Objection to Planning Application LU/3/11

Rear extension, Garden Store
@ Berry House, Berry Lane, Littlehampton

Rear - North

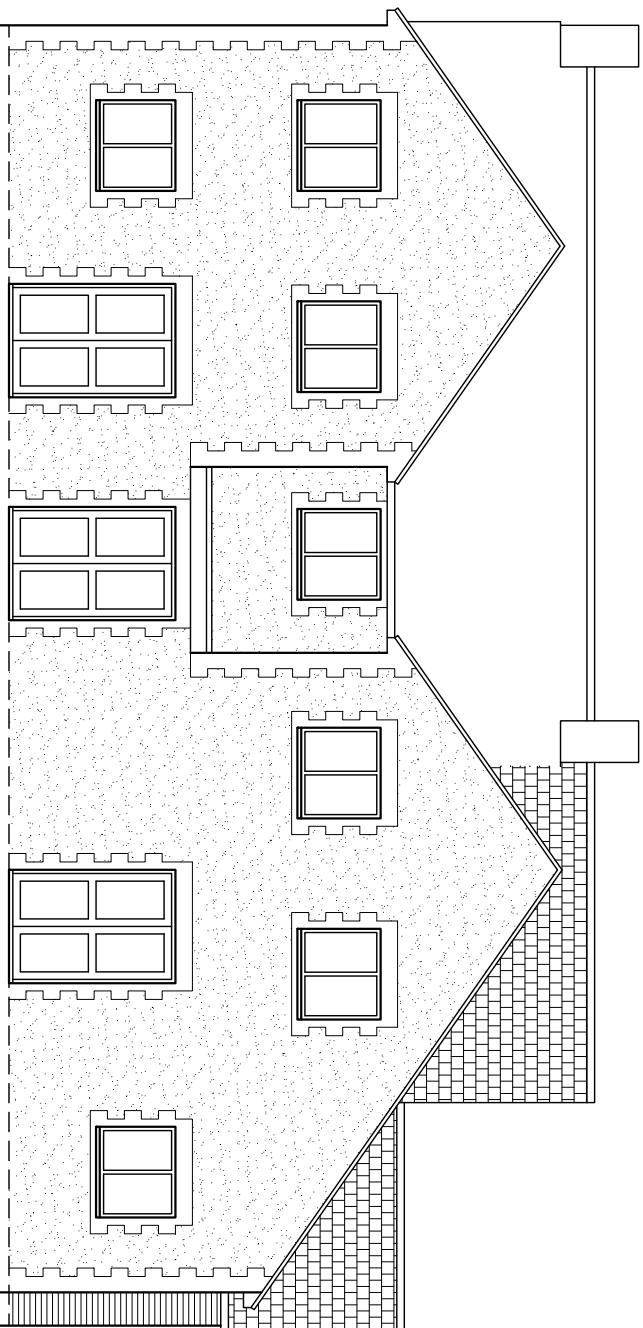
The rear elevation, which currently has two windows, is now brought forward by 4 metres and which being sixteen metres wide, looks like two buildings and has 5 overlooking windows intruding on our privacy.

Drawing:
First floor as proposed

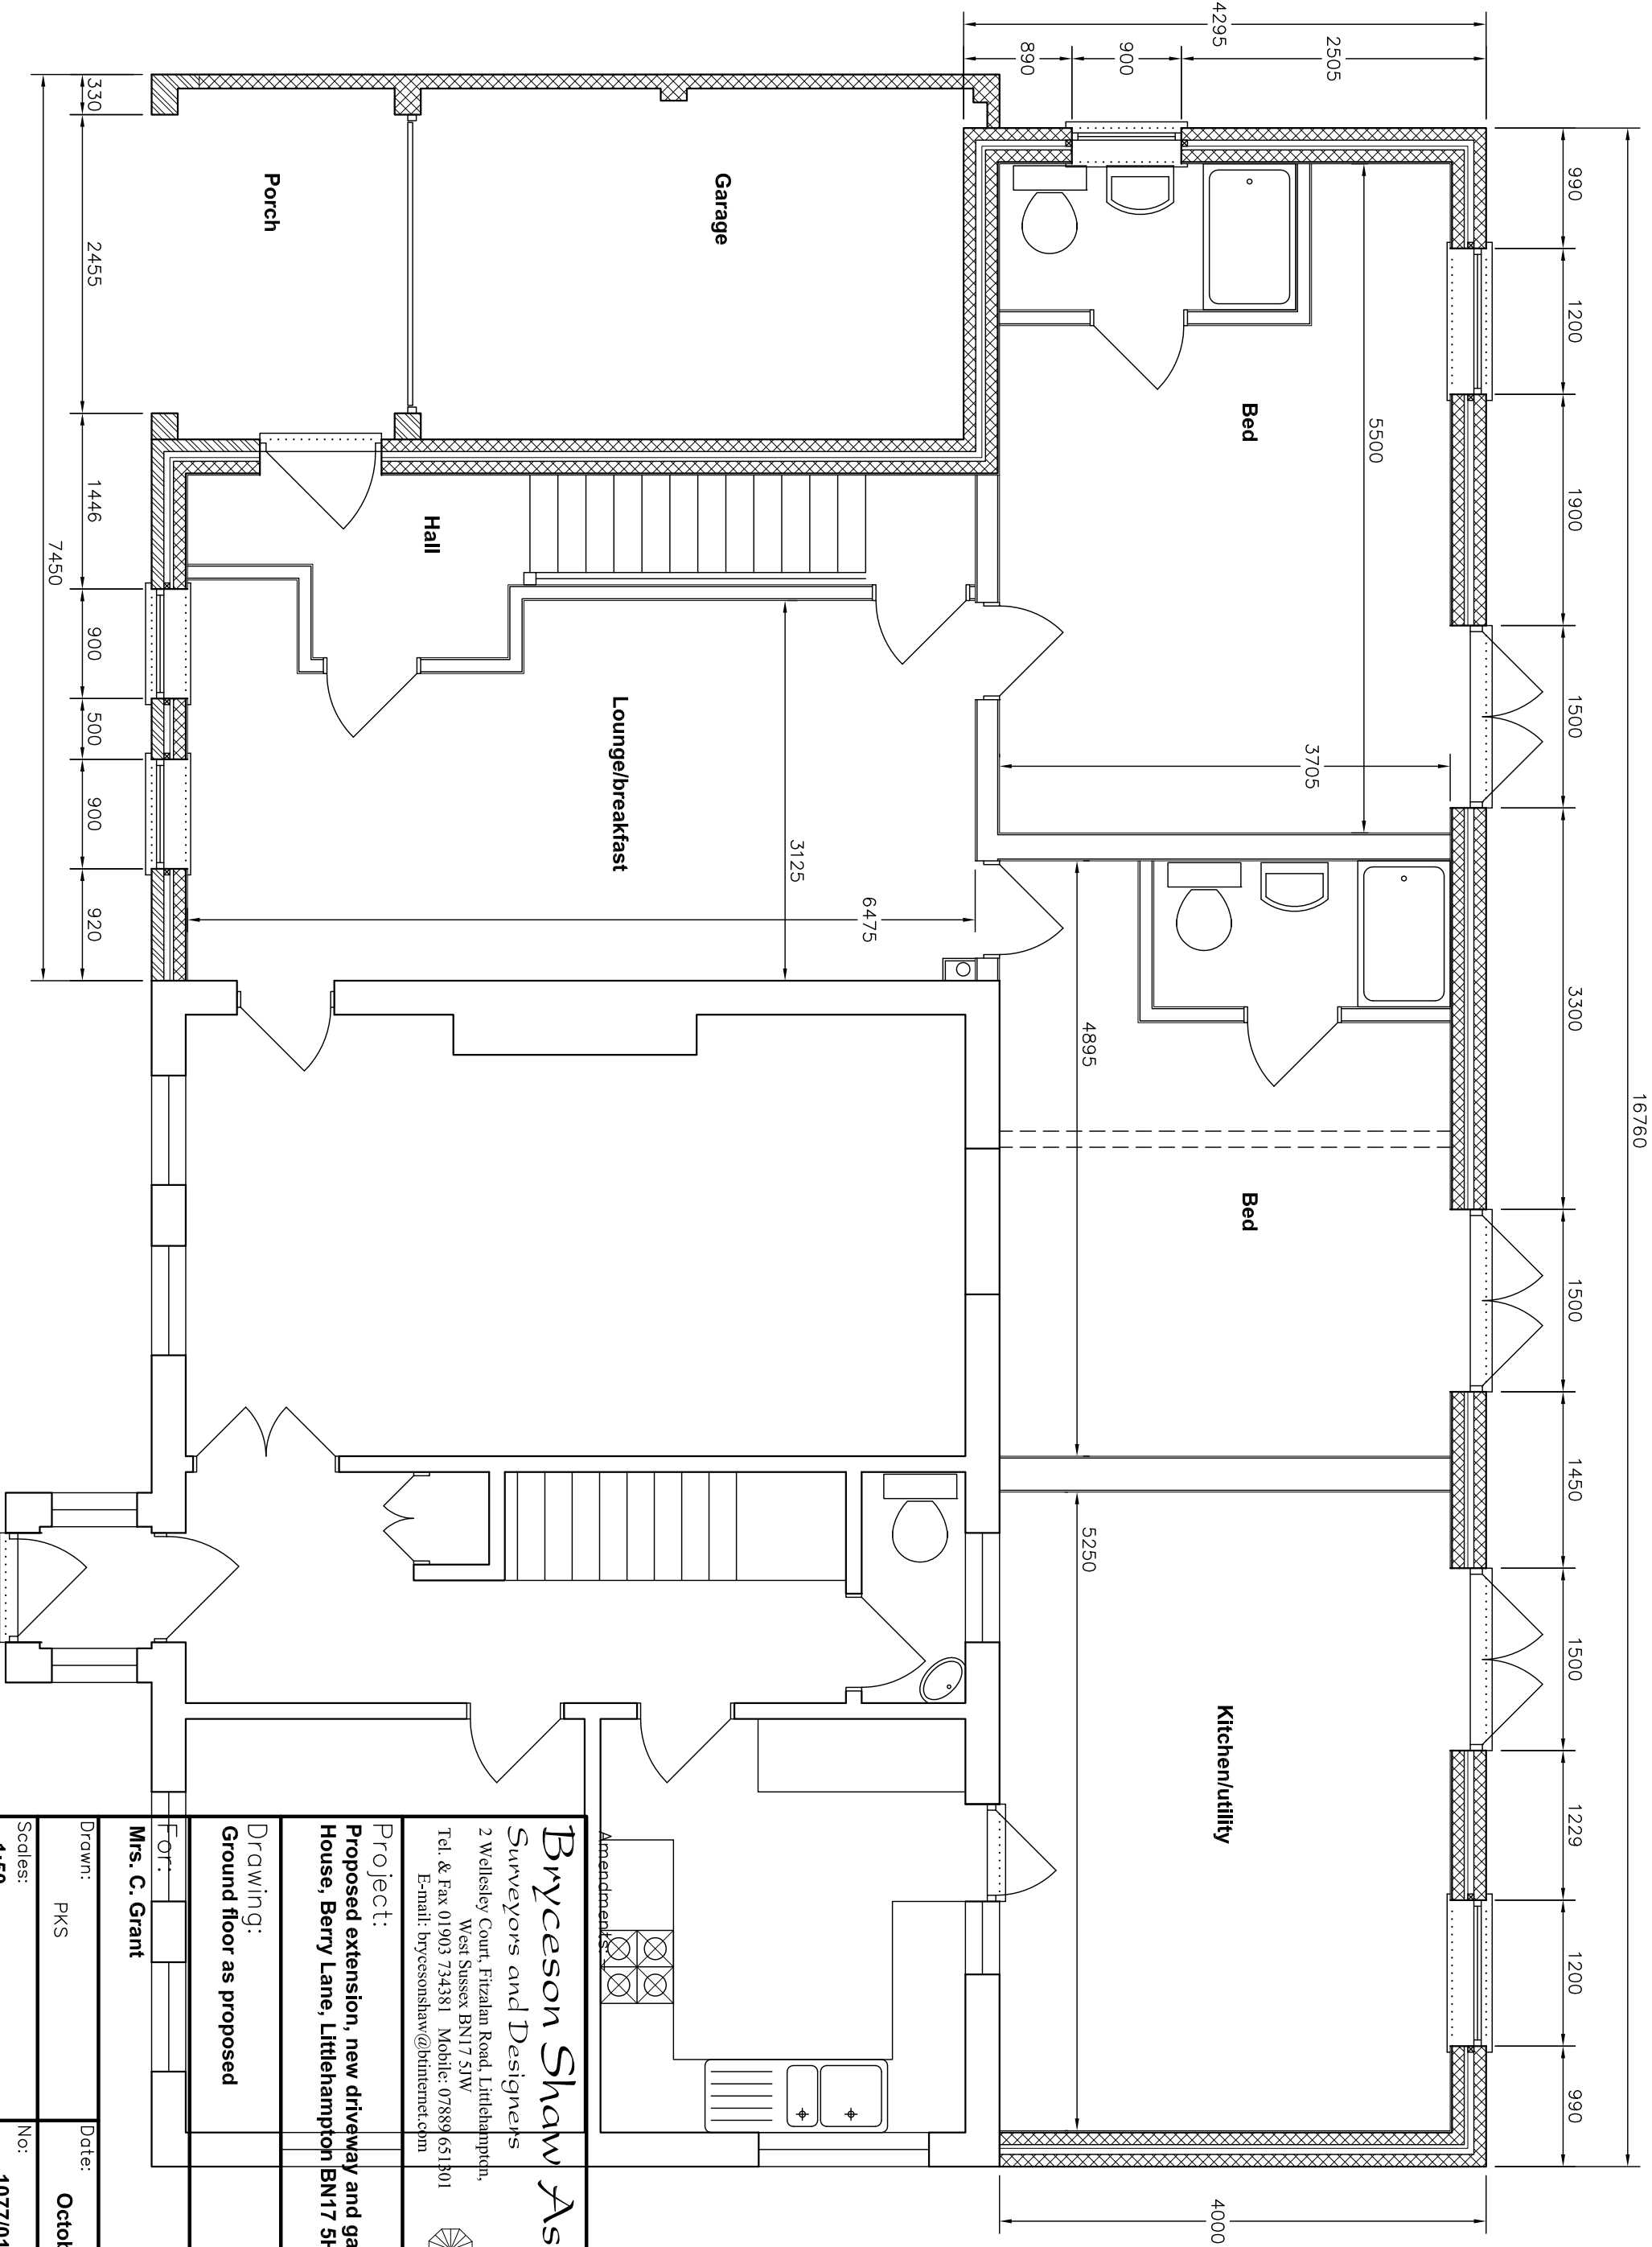
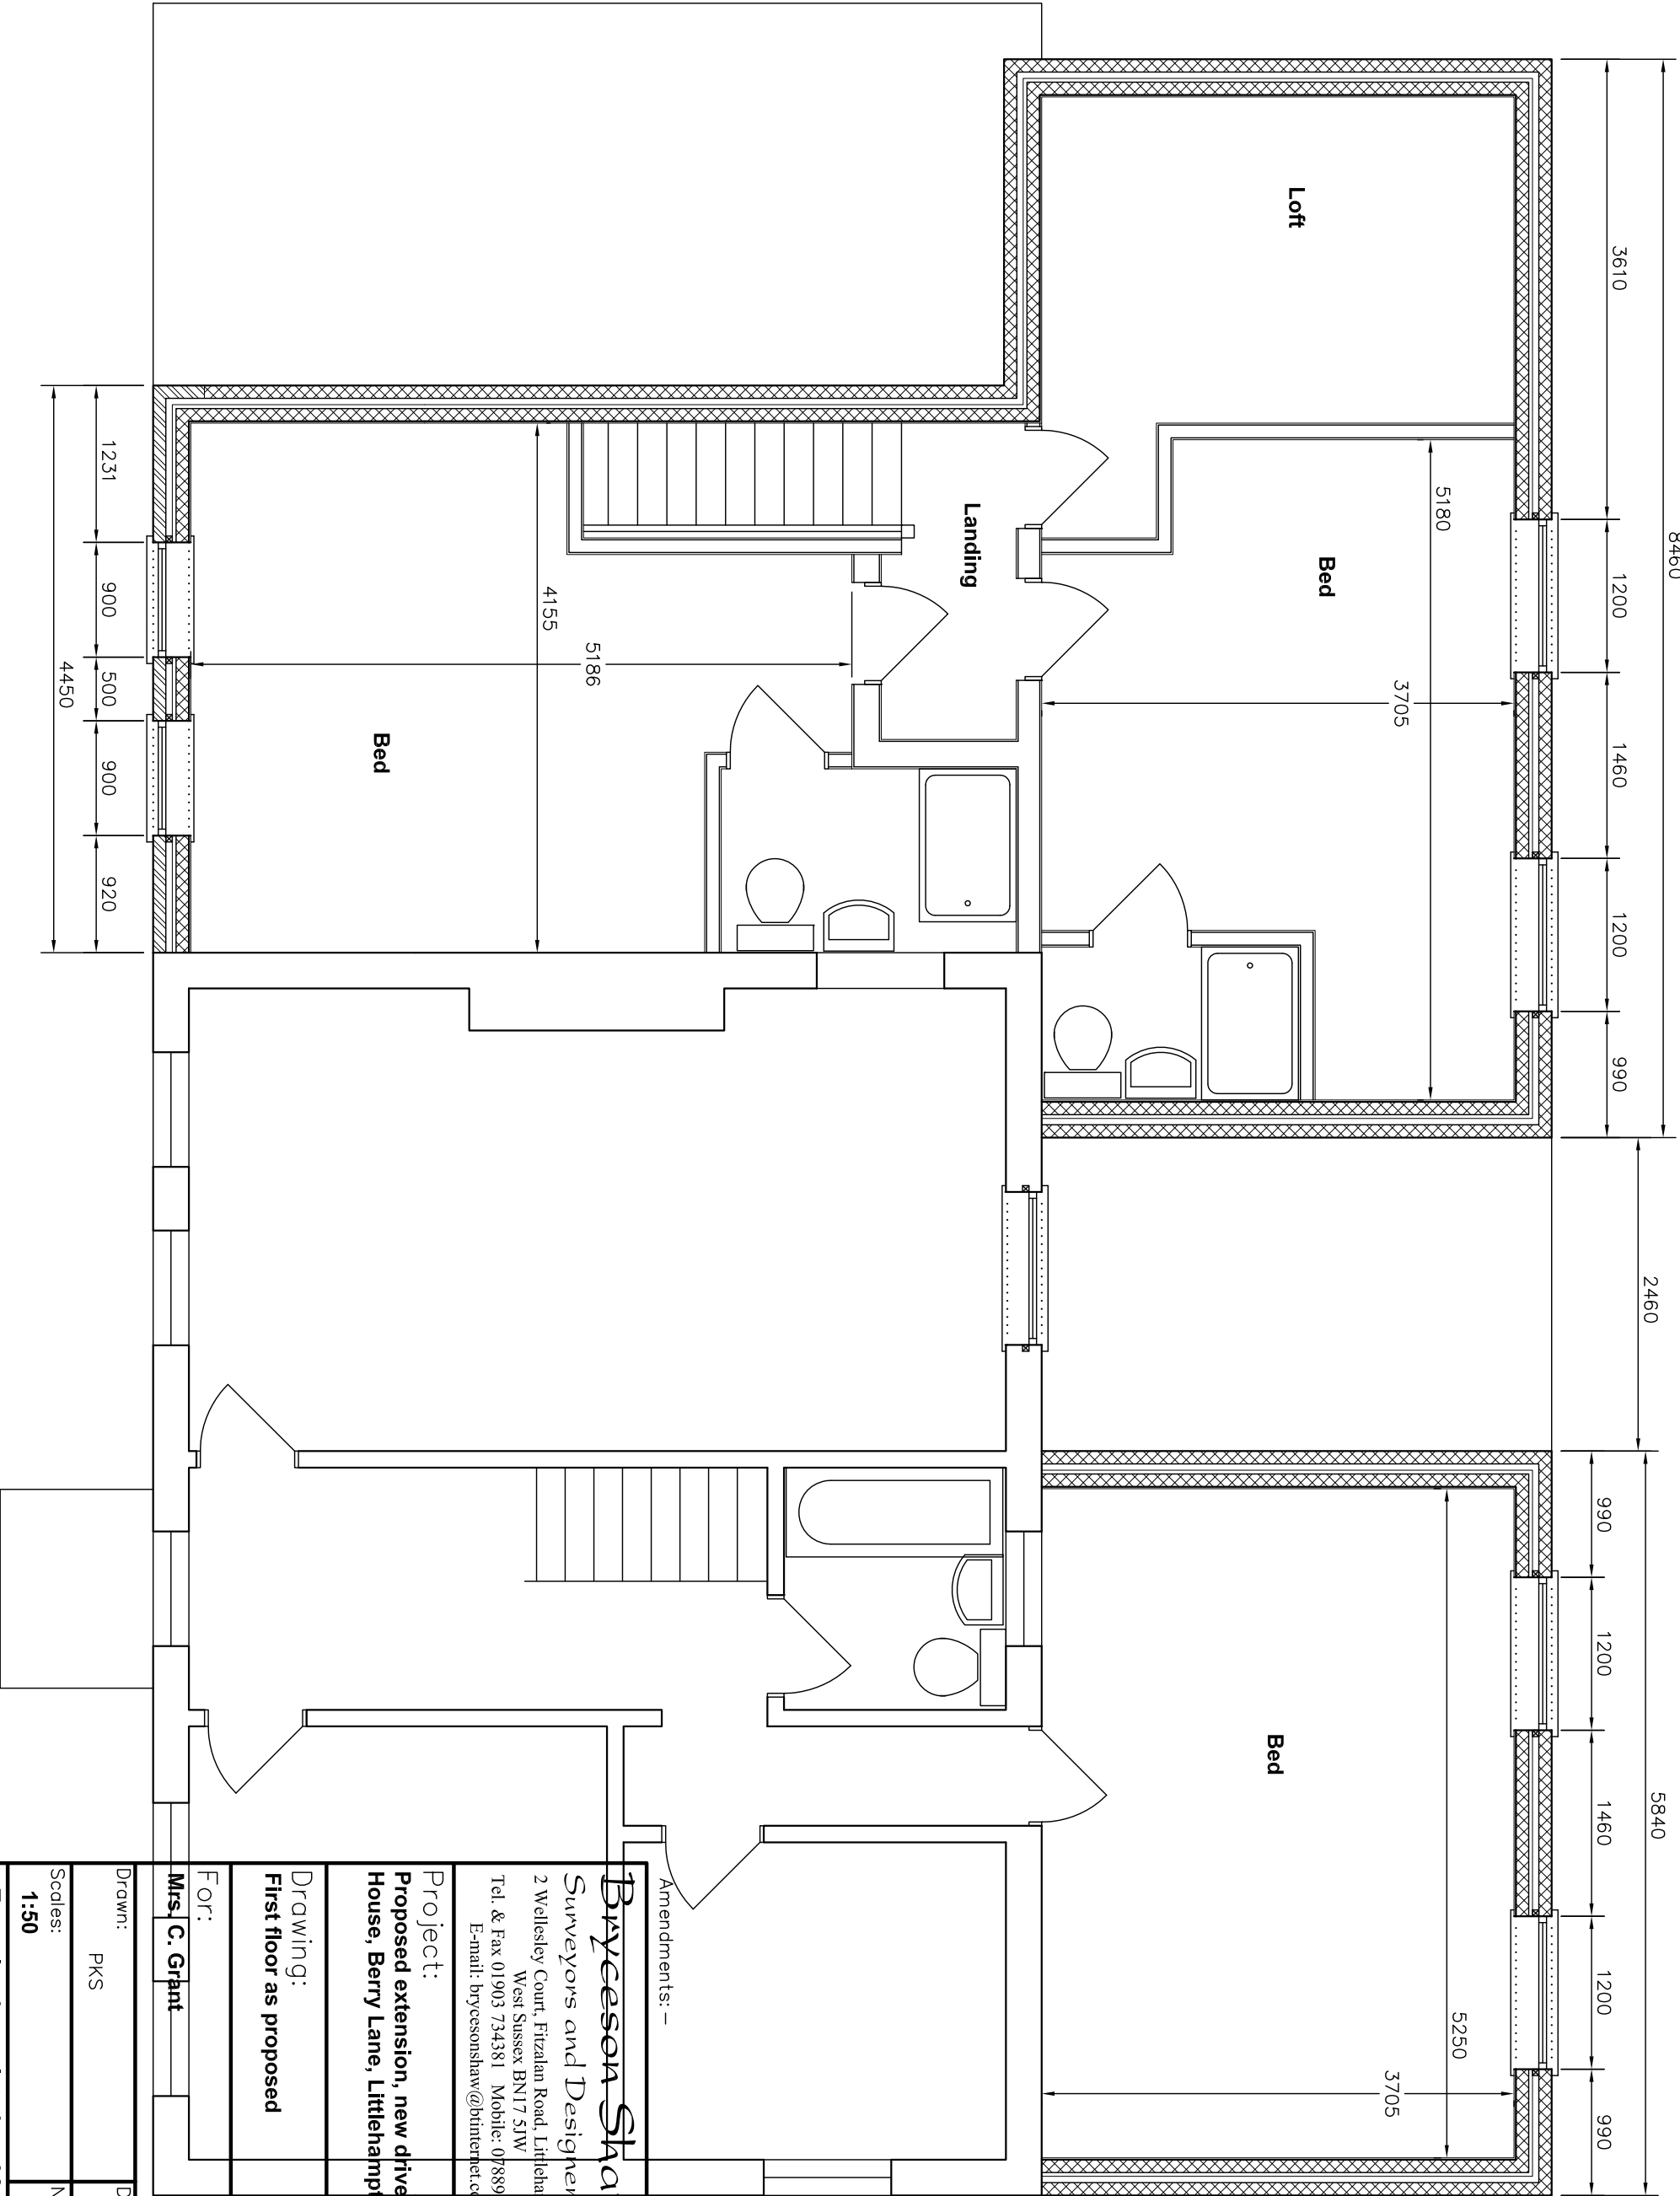
The width of the Ground and First Floor plans are being extended from West to East by 100% of that shown on application LU/44/10. (ie from 8.4m to 16.7m) This is NOT a minor amendment.

The extra rear roofs make the house look like 2 houses. Internally this also applies as there are 2 front entrances & 2 staircases with just 1 door connecting the 2 sides. This is not in keeping with the local area.

Block plan

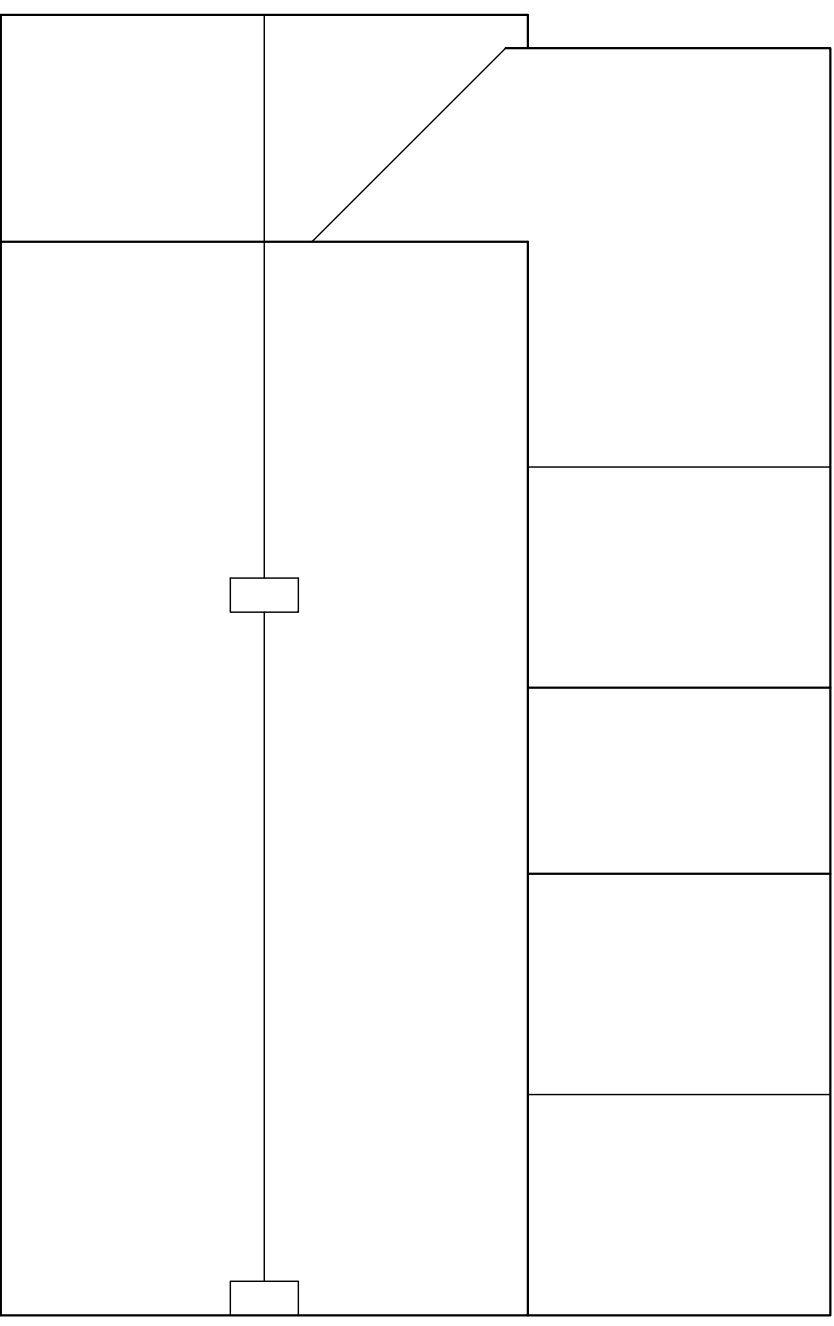
Please note the block plan is incorrect
as the rearward extension of 11 The Estuary
is not shown. This makes the proposed
works nearer to my property than is
shown on the plan.
